Historic Environment - Archaeology Planning Consultation Comments

RE: 19/00522/NSIP **Proposal Site: Potential Aquind Interconnector Site, Old Mill Lane, Lovedean, Denmead**

Tracy Matthews
Historic Environment (Archaeology) Officer
03/02/2020

TITLE: **Application document reference 2.12 Hedgerow and Tree Preservation Order Plans Sheet 2 of 10**

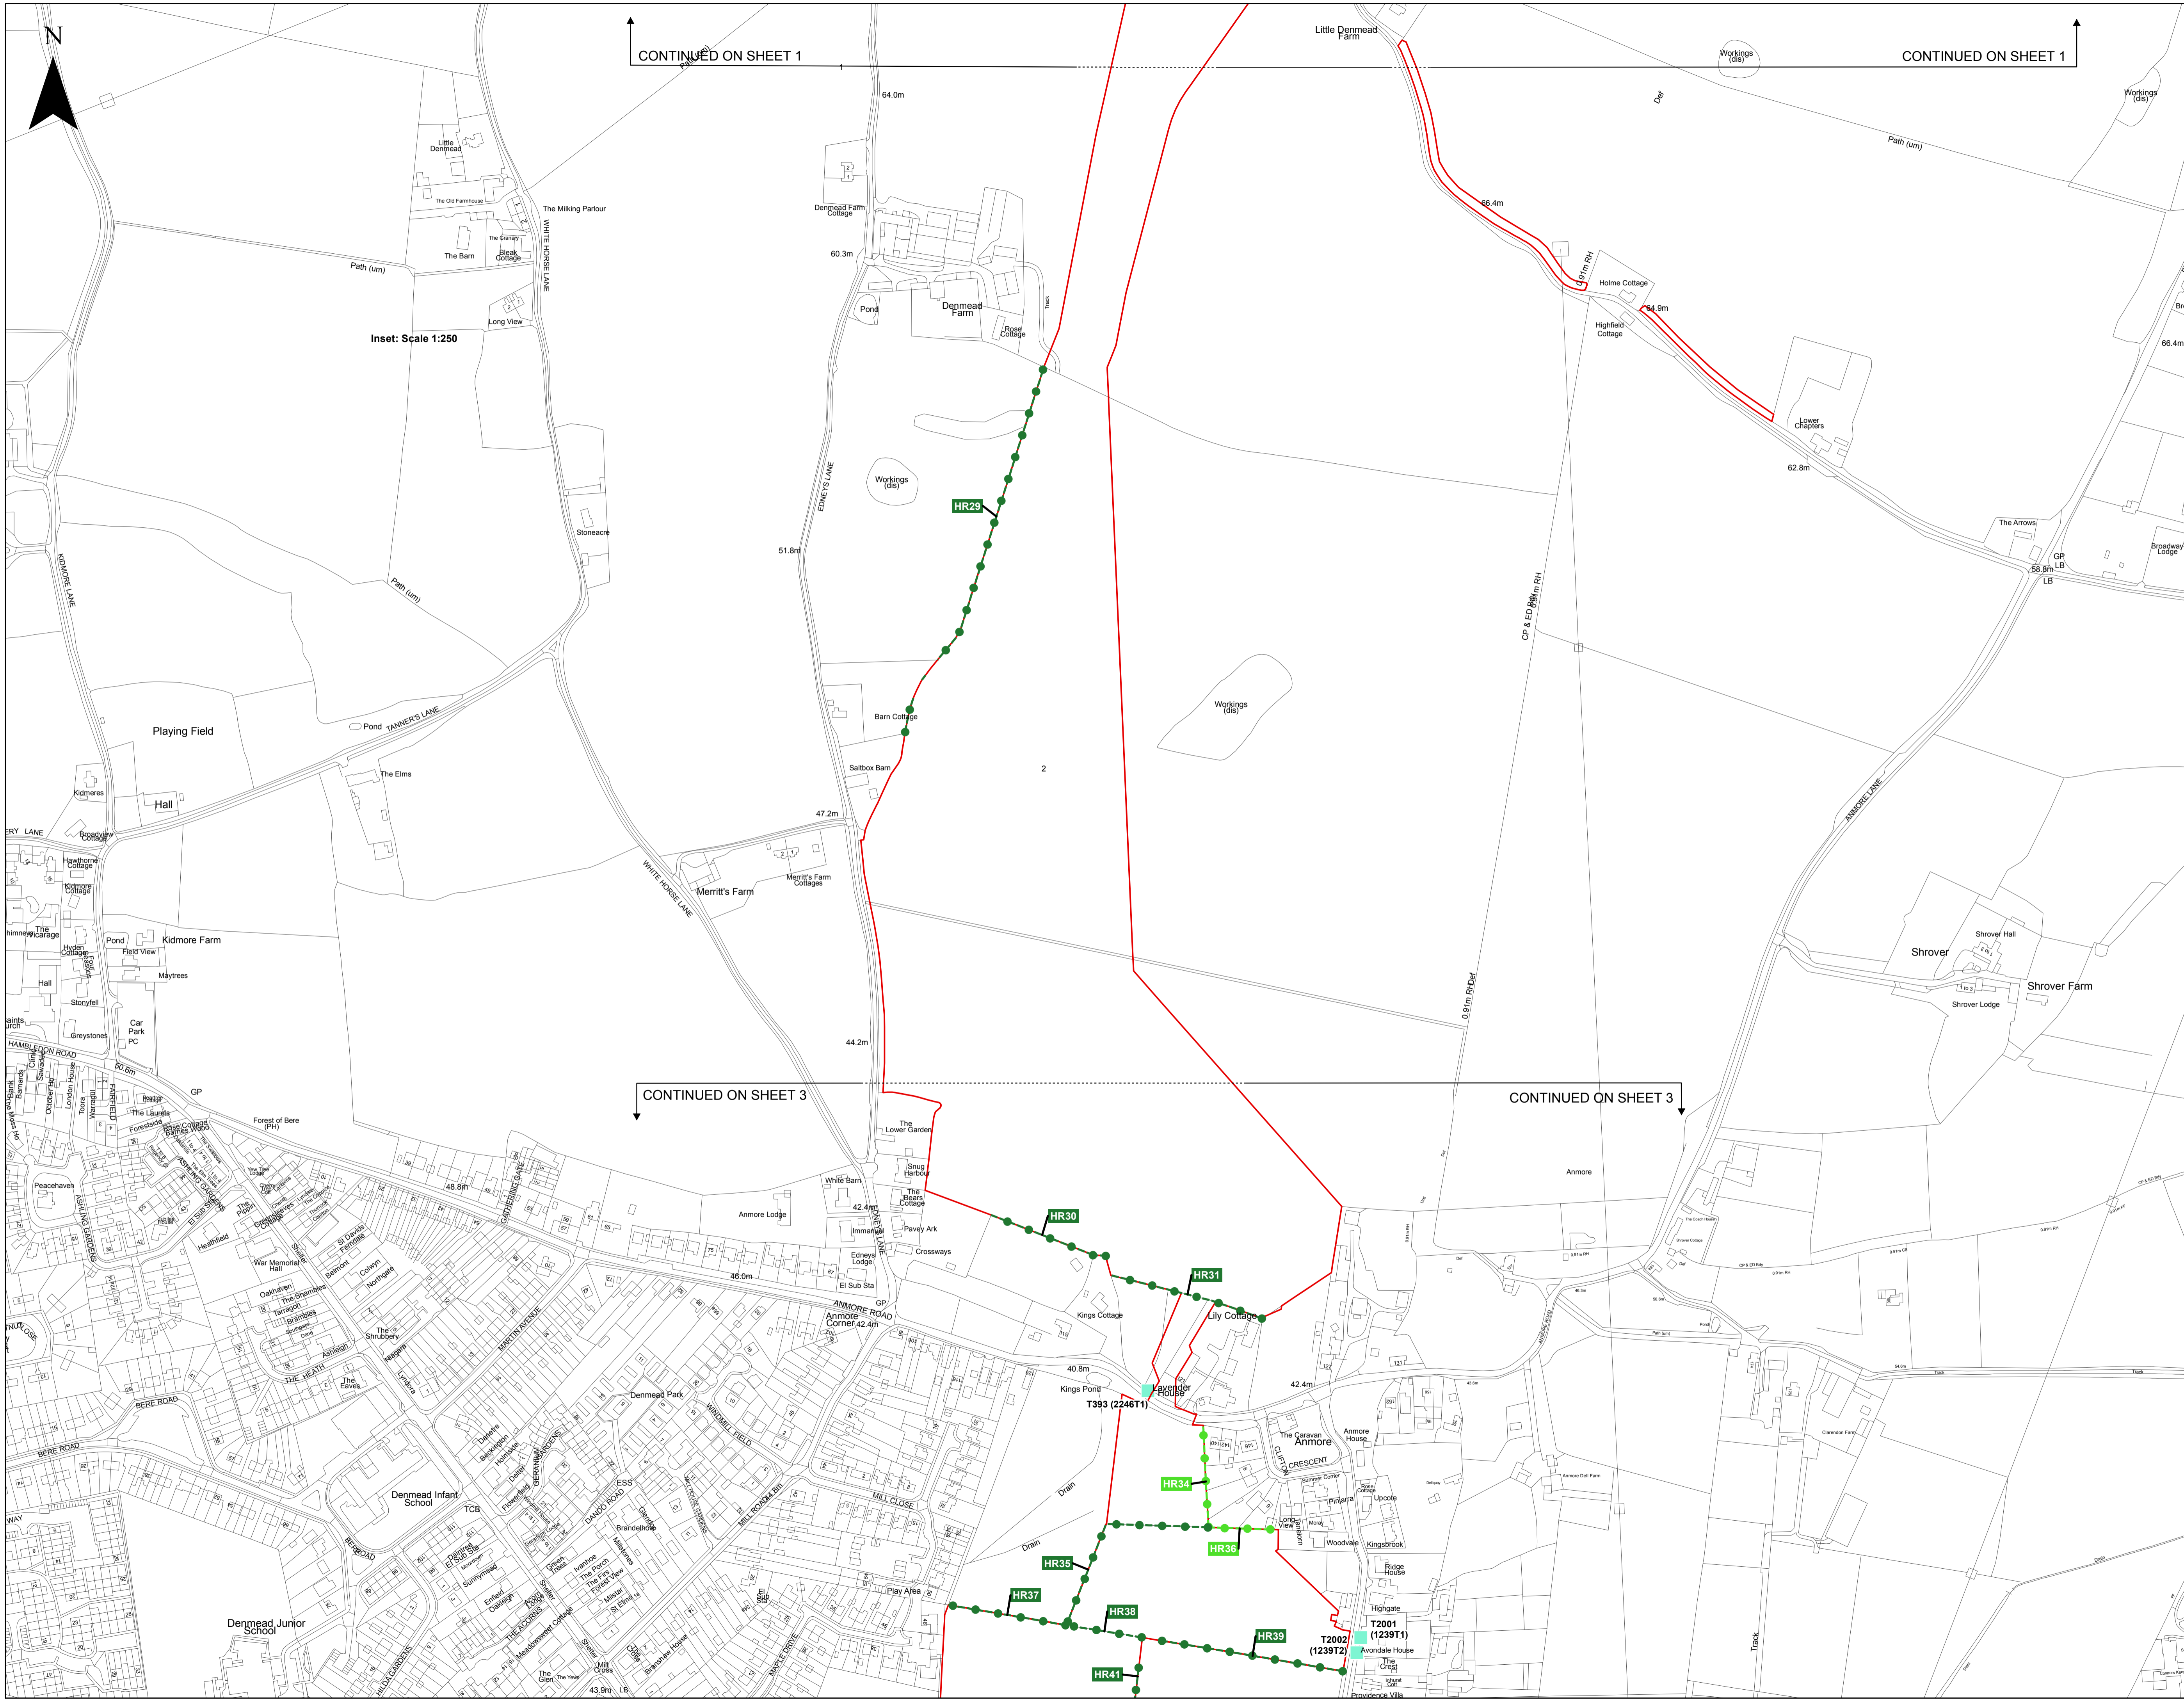
One hedgerow with the Order Limits has been identified as ‘important’ under the Hedgerow Regulations (heritage criteria) and marks an historic parish boundary (Para. 21.5.2.4, ES Vol 1 Chapter 21, document ref. 6.1.21). This is identified as **A158**, in section 1.4.1 of the DBA and as **HR02** on 2.12 – Hedgerow and Tree Preservation Order Plans Sheet 1 of 10.

Table 21.1 of ES Vol 1 Chapter 21 Heritage and Archaeology (document ref. 6.1.21) indicates that this hedgerow has been ‘scoped out’ as it would not be impacted by the Proposed Development. The retention of this hedgerow is welcomed and this is confirmed by Part 7 41._(4) (b) and Schedule 12 of the draft DCO (document ref. 3.1).
